Project: Sandstone Precinct

Subject: Re: DA Condition B7a - Nib Wall Pack

PLAN DETAIL

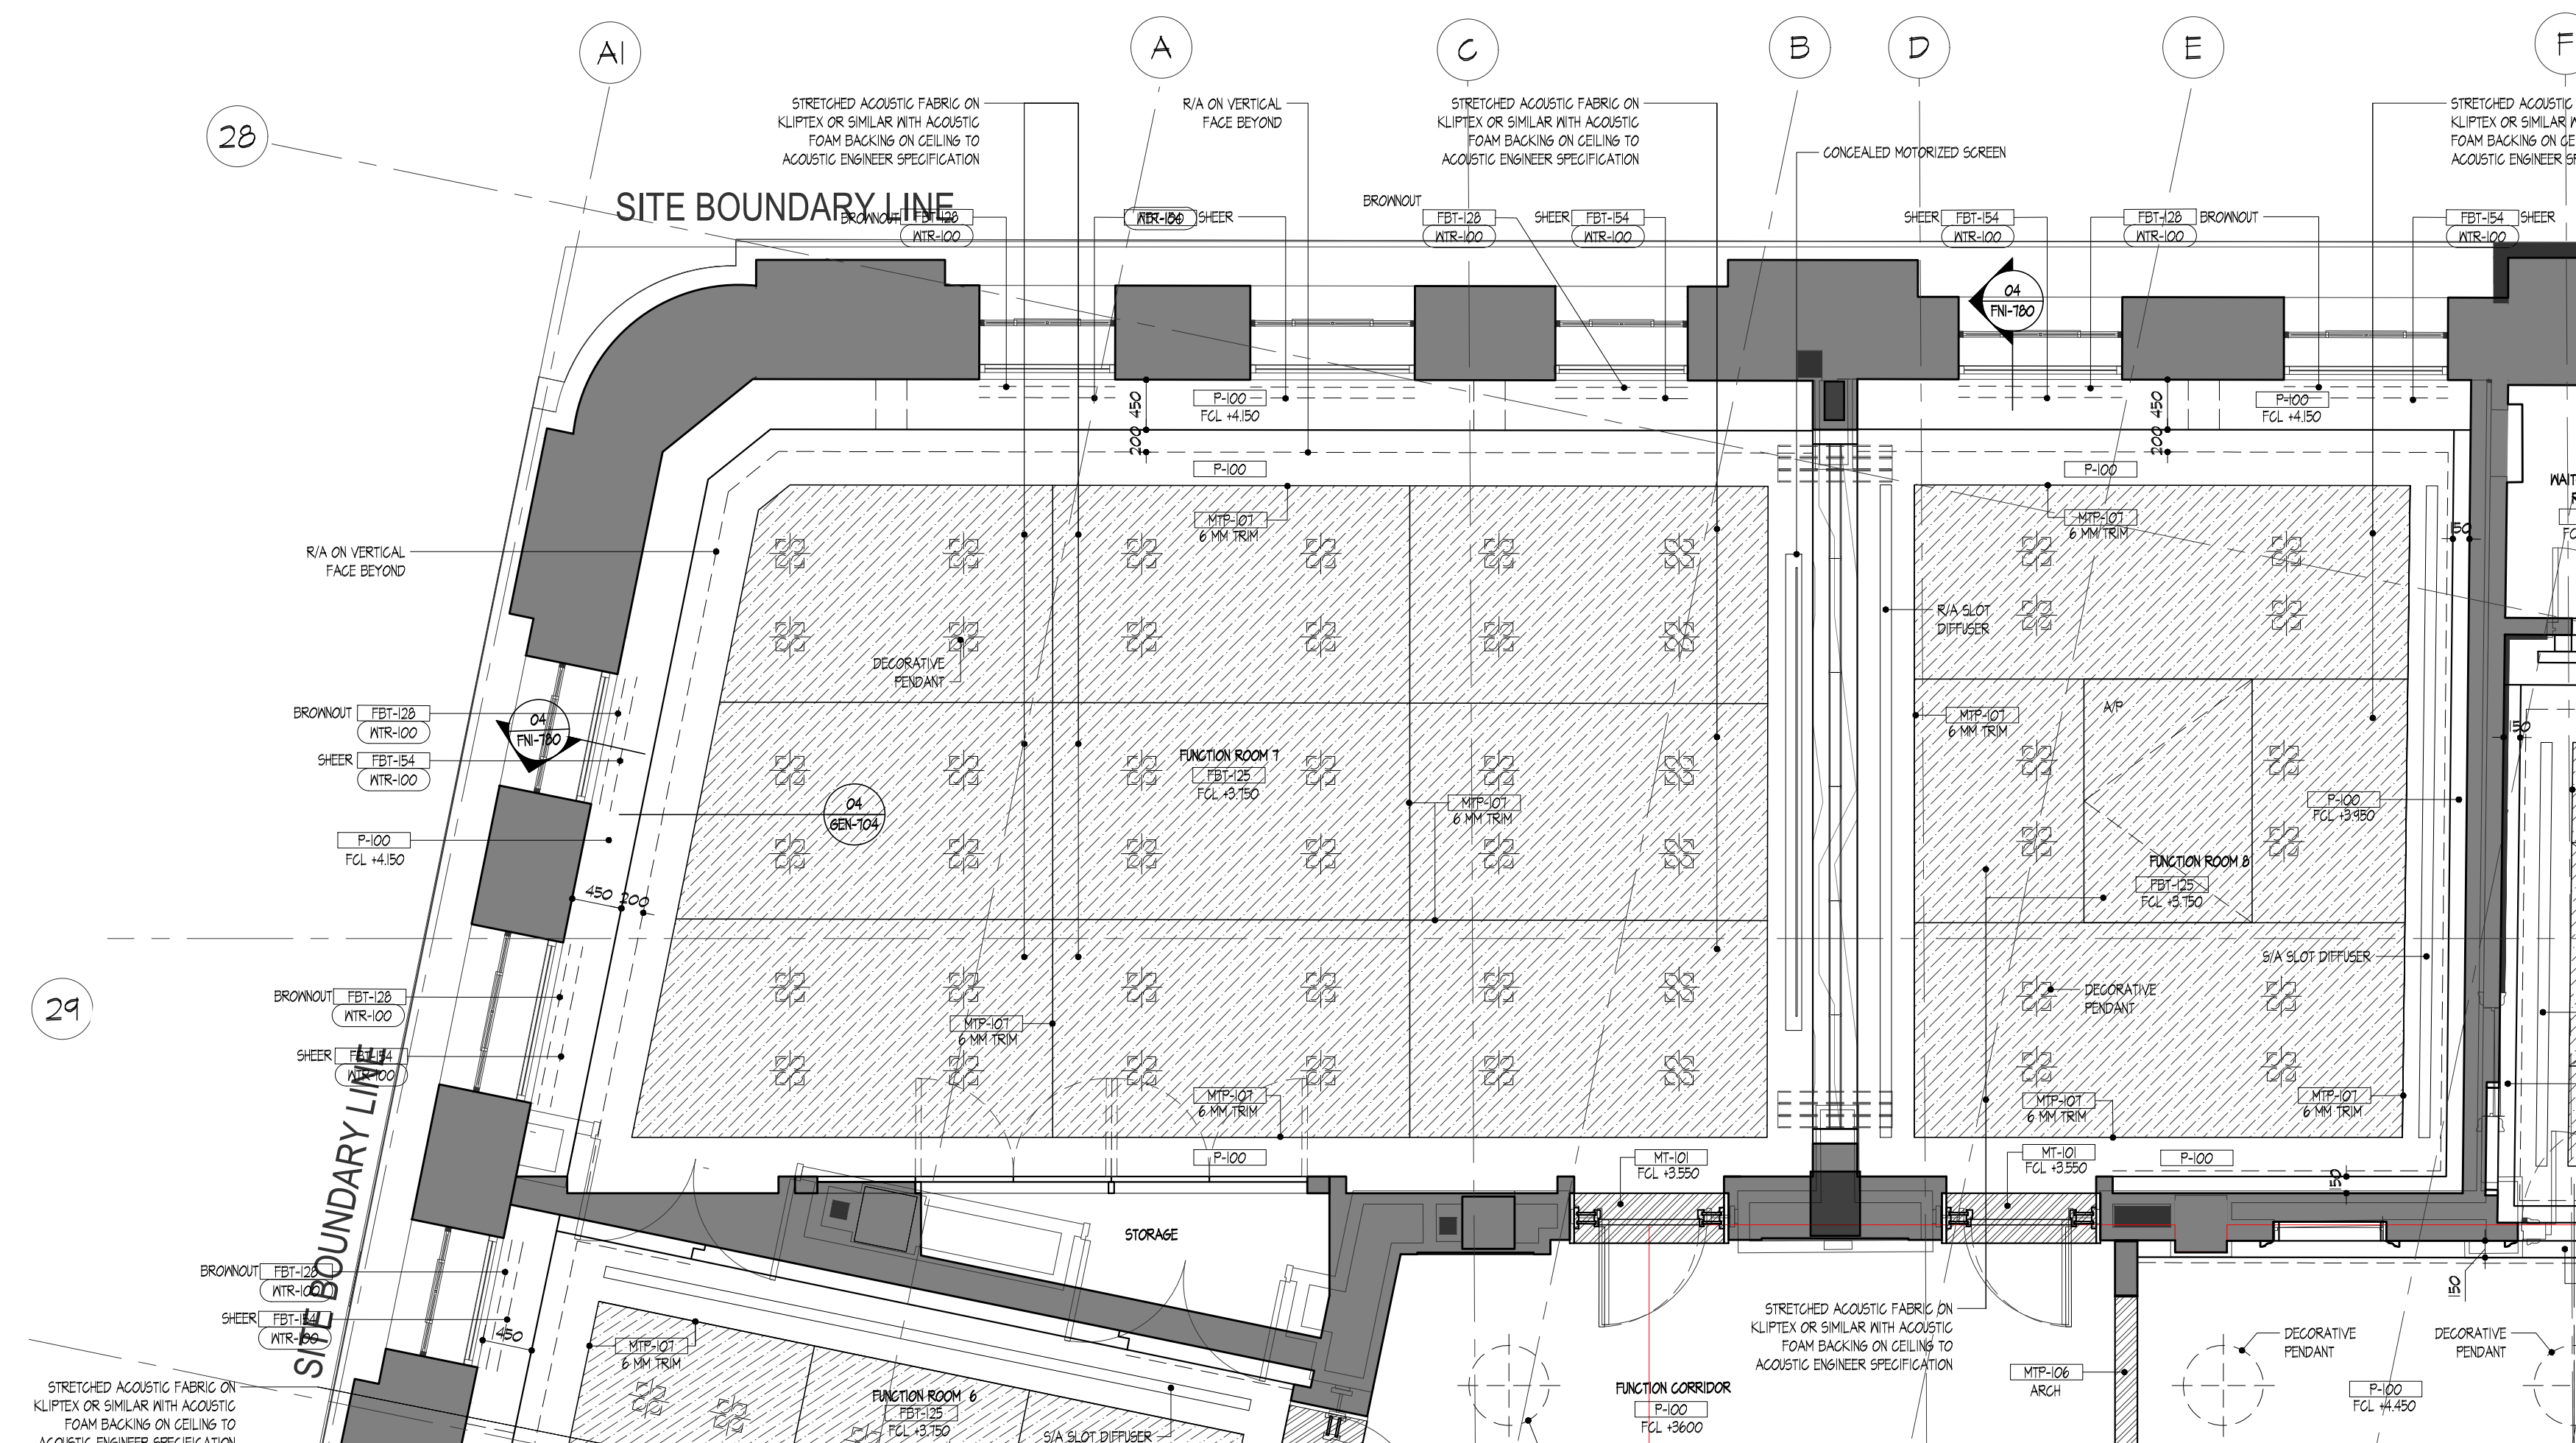
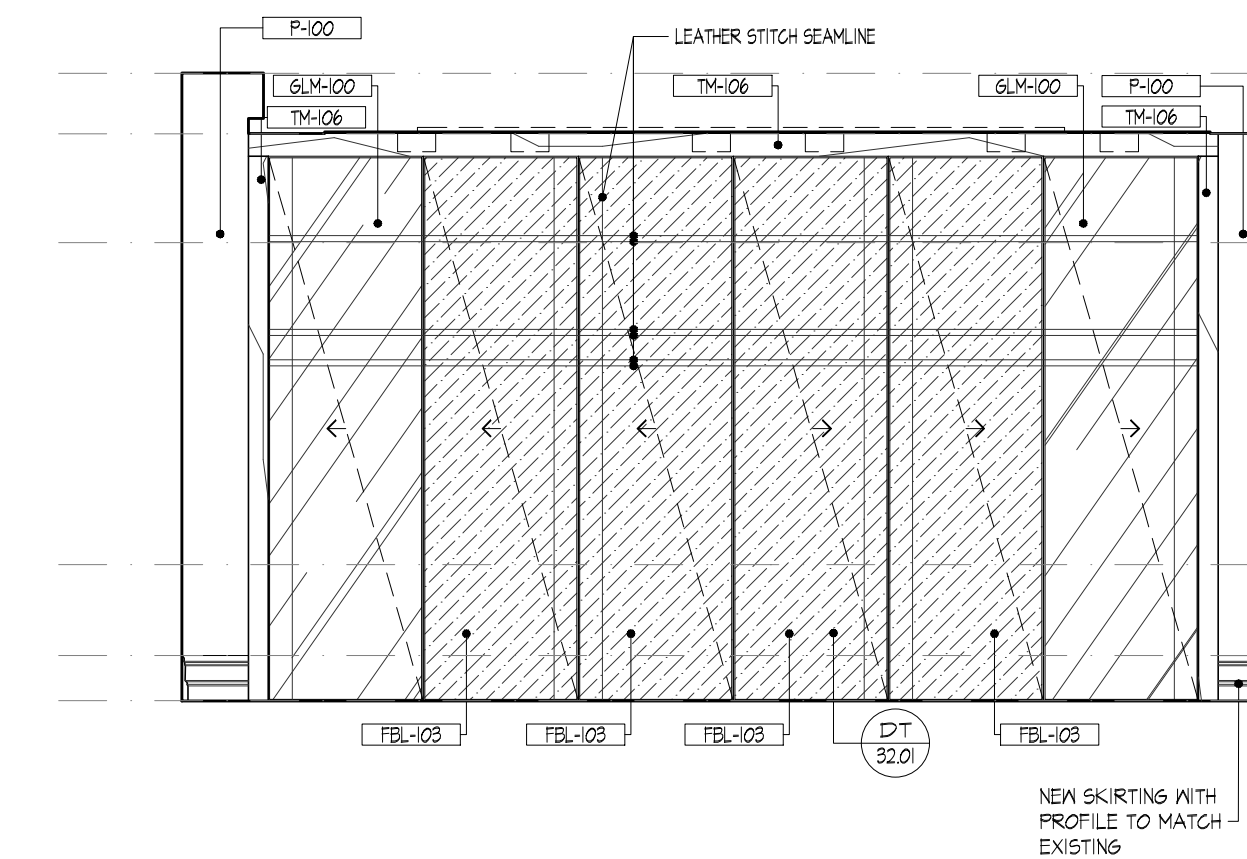
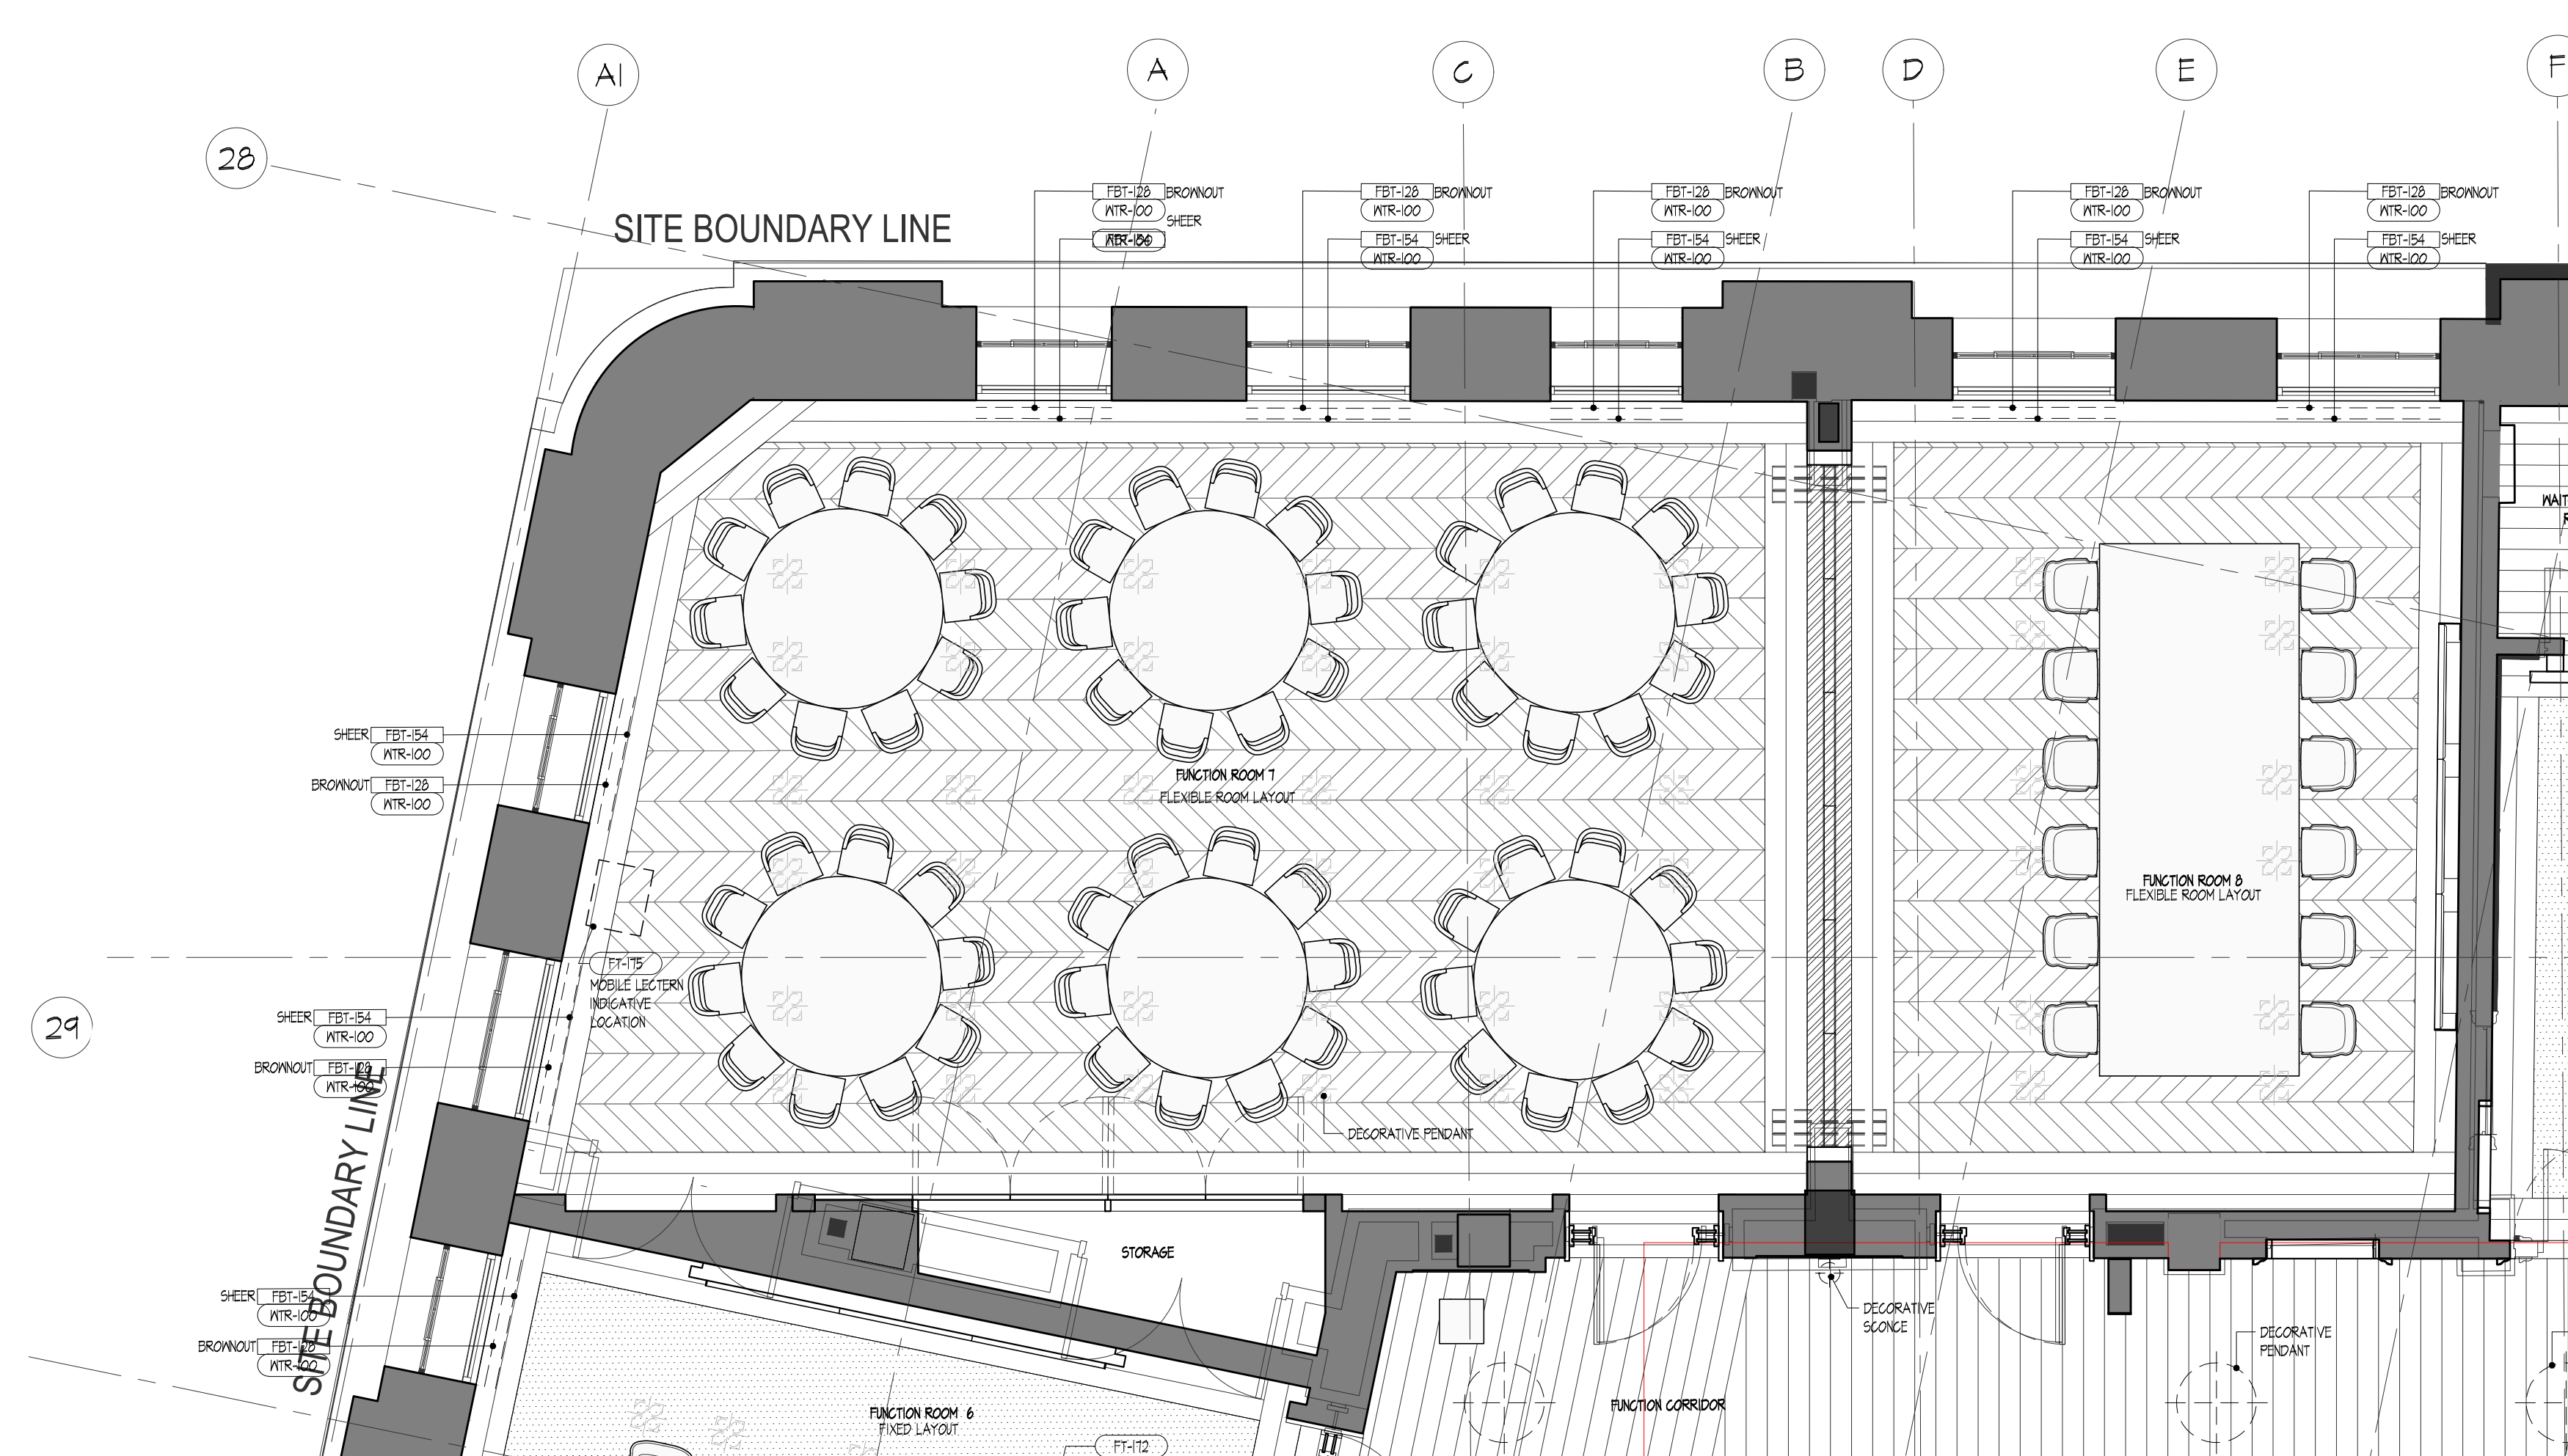
Further can the plans clearly show, via labelling, the line in the flooring and the substantial wall nibs and head.
